CITY OF ALBUQUERQUE

**RE: Chipotle Shell 98th Street
241 98th Street NW
Grading and Drainage Plans
Engineer's Stamp Date: 6/25/2025
Hydrology File: K09D038A
Case # HYDR-2025-00231**

Based upon the information provided in your submittal received 6/30/2025, the Grading & Drainage Plan **is not approved** for Building Permit. The following comments need to be addressed for approval of the above referenced project.

SHEET TITLE: GRADING & DRAINAGE PLAN

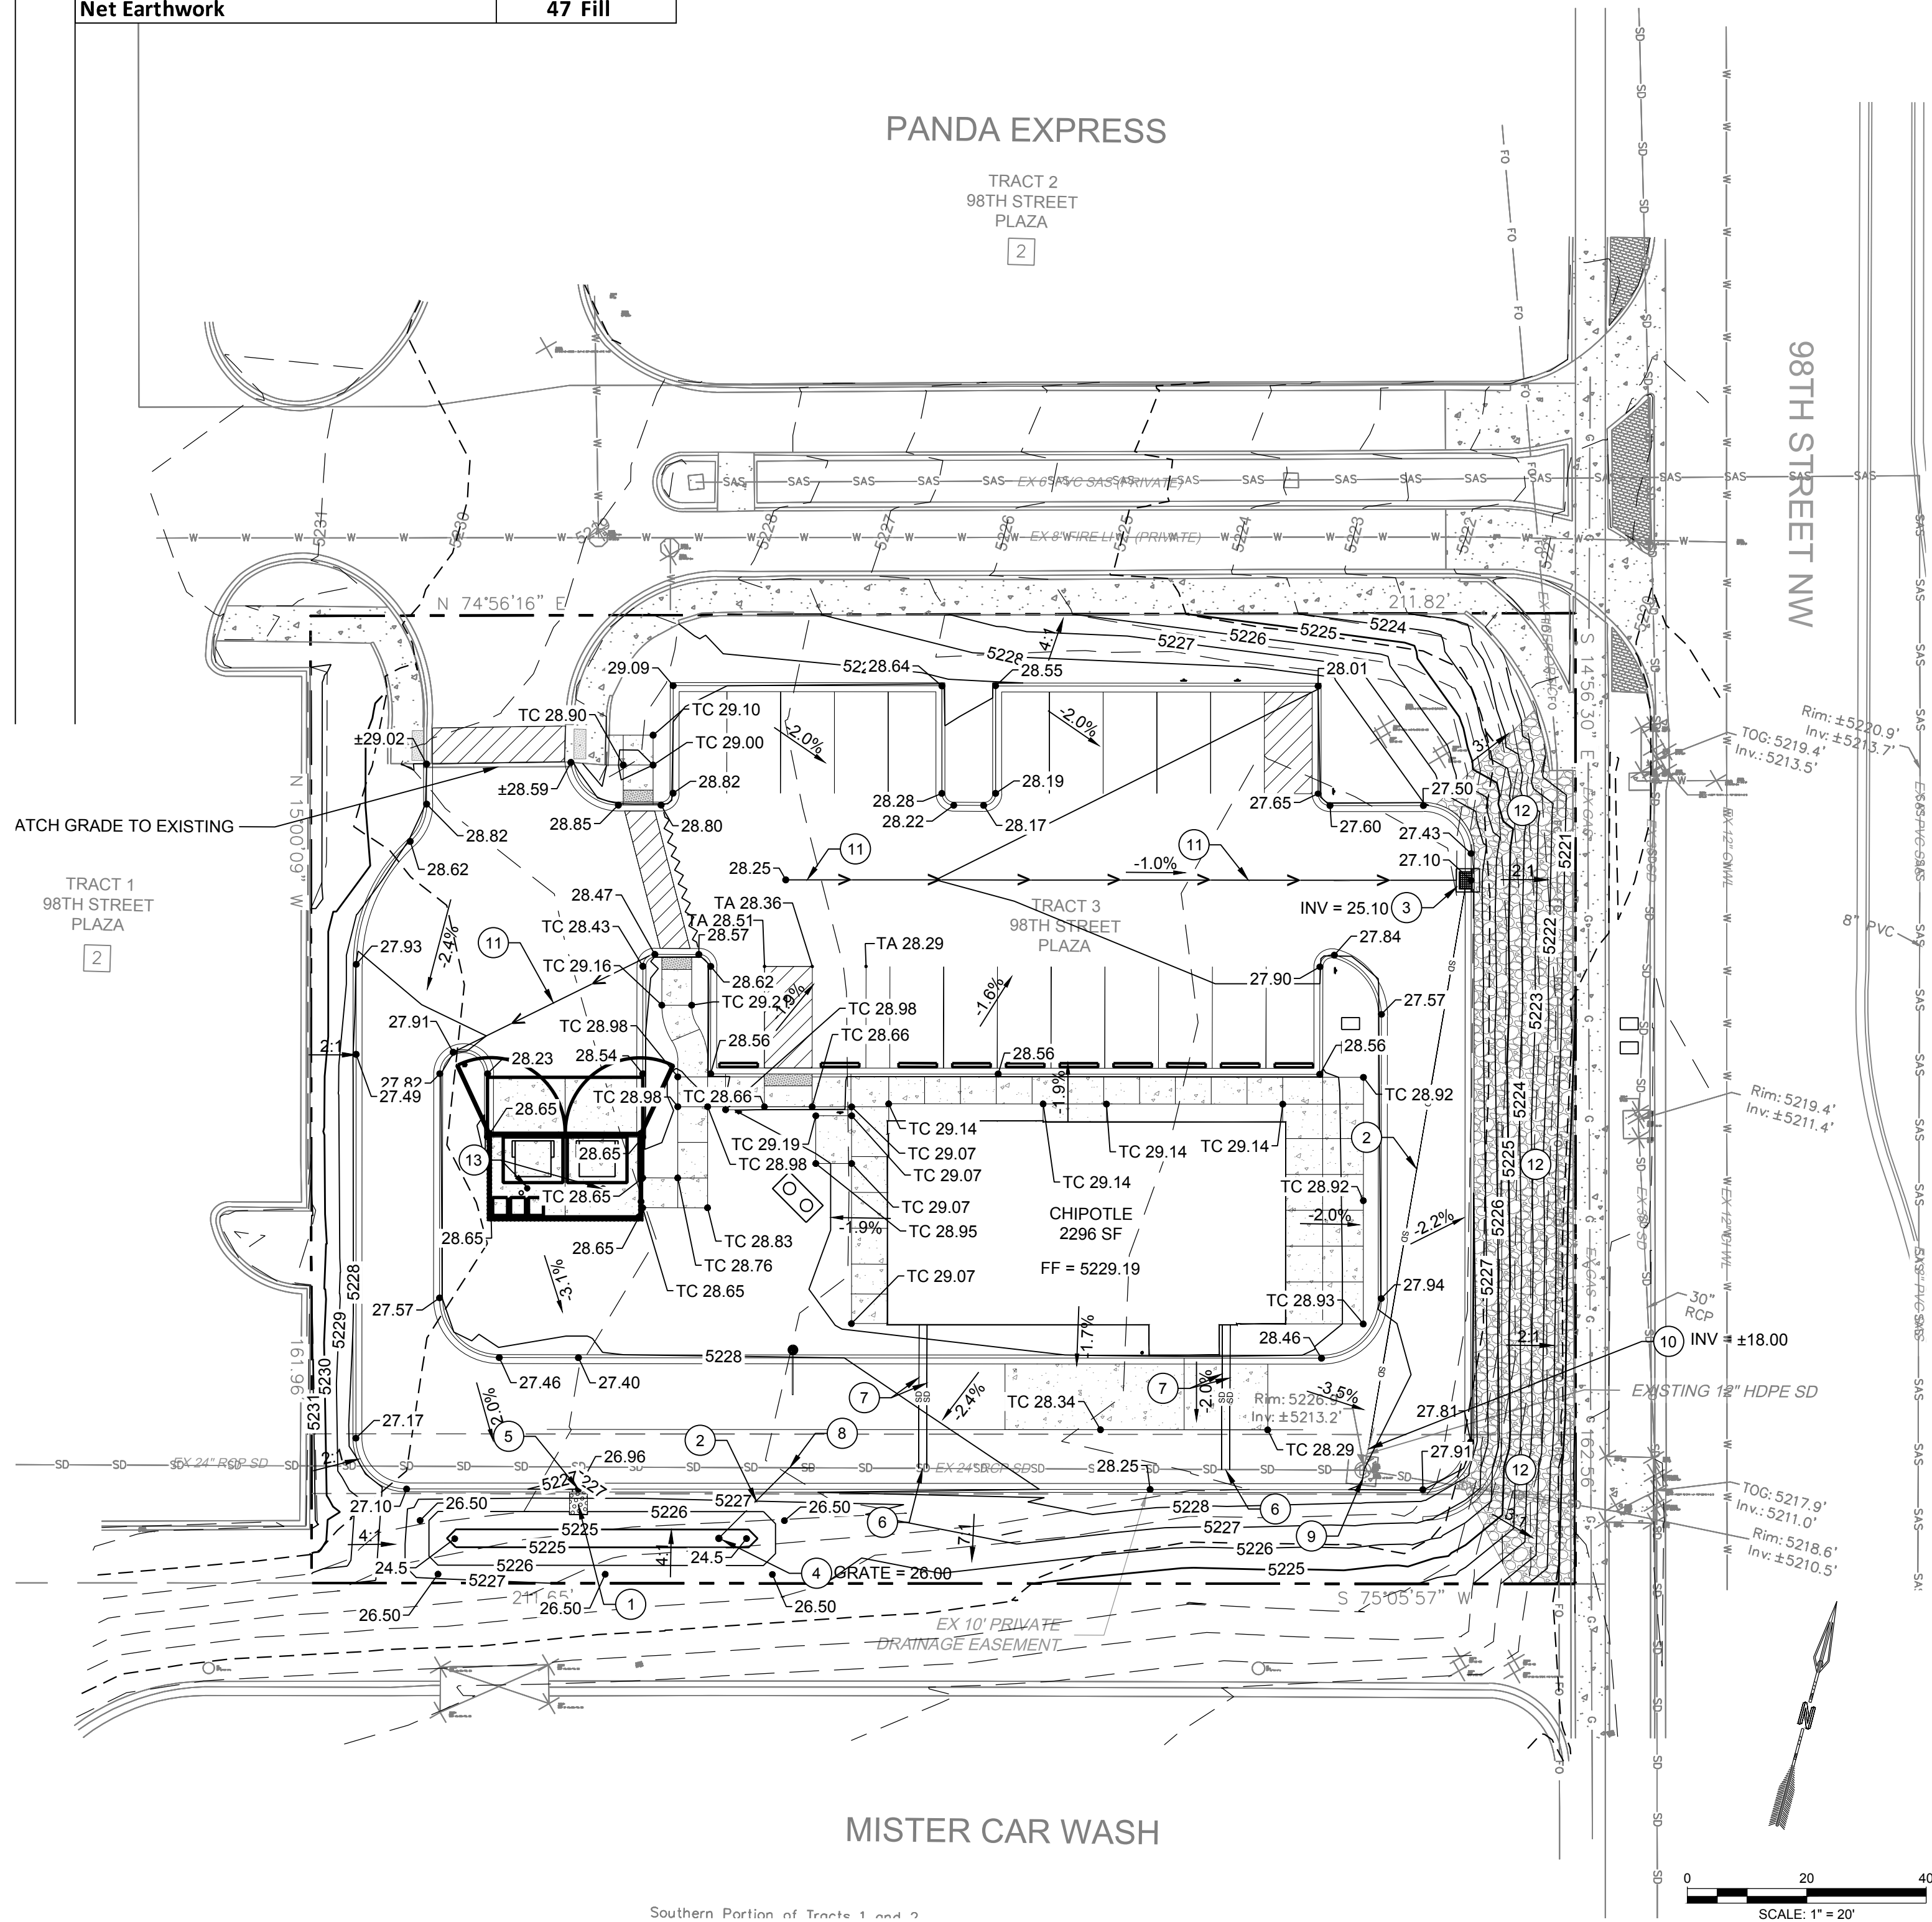
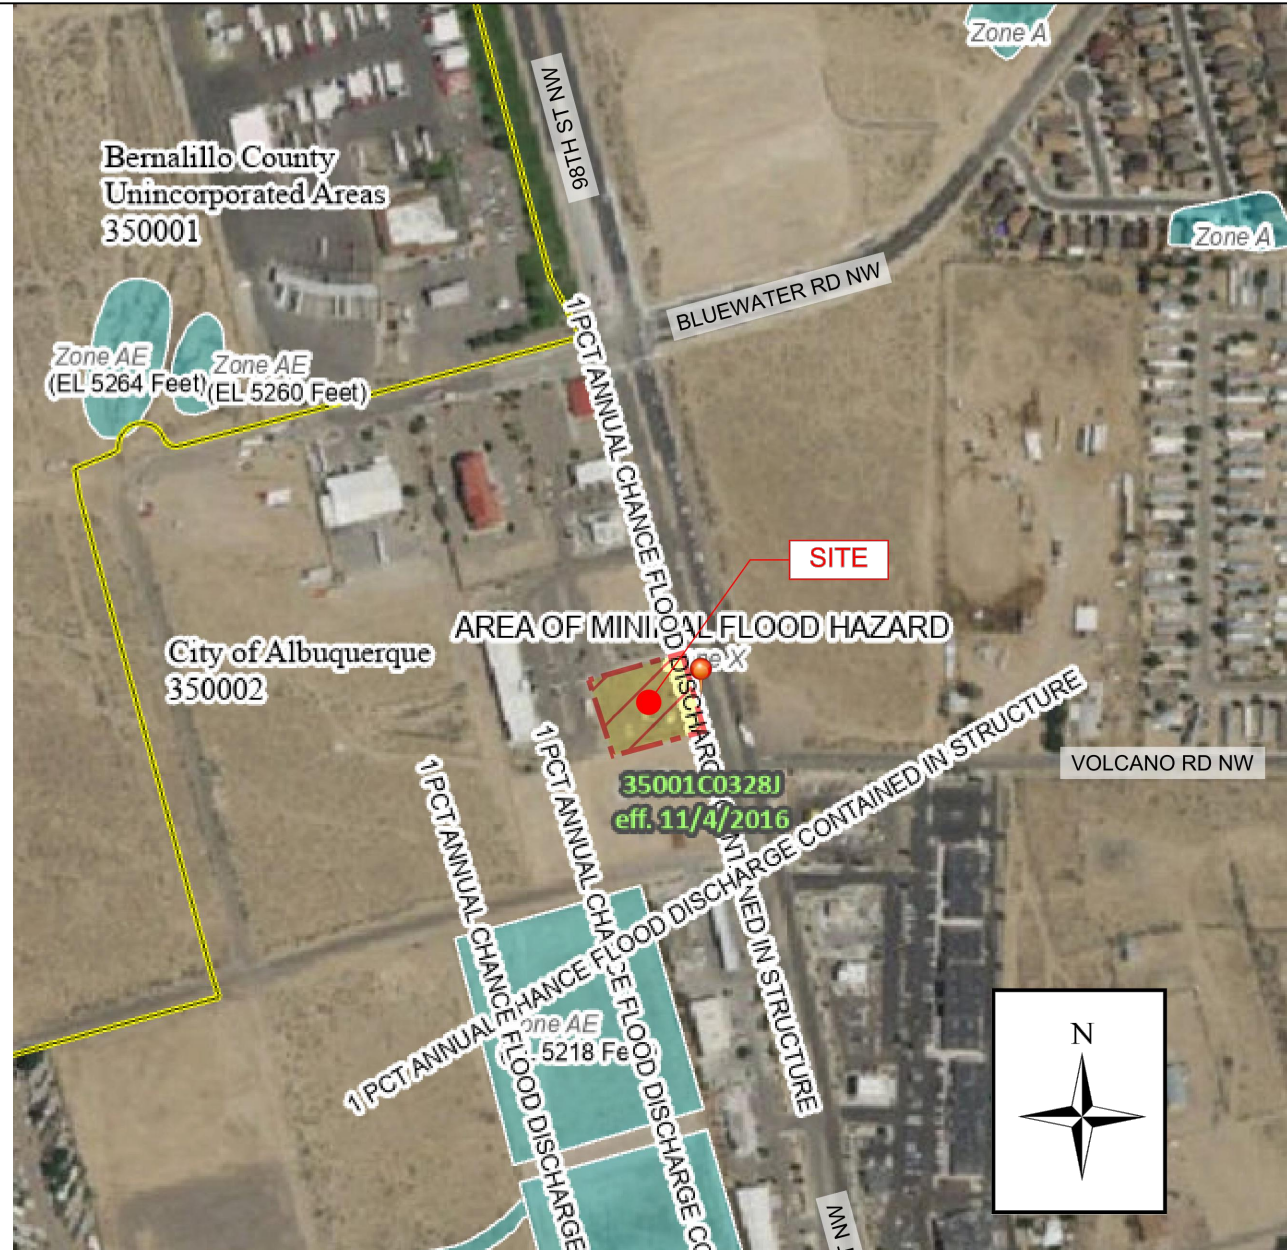
1. Please provide the FIRM Map and floodplain note with effective date.
2. For trash enclosures serving food service developments, trash enclosures must demonstrate control of liquids from dumpster areas per DPM by containing runoff from the dumpster area, preventing outside drainage from entering the dumpster area, and discharging to the sanitary sewer. Please show an inlet in the middle and label. "Inlet to be connected to the sanitary sewer. See Utility Plan."
3. A proposed retaining wall is shown in the Legend. Provide the existing and proposed grades on both sides of the proposed retaining wall(s).
4. Complete the Payment-In-Lieu for SWQV.
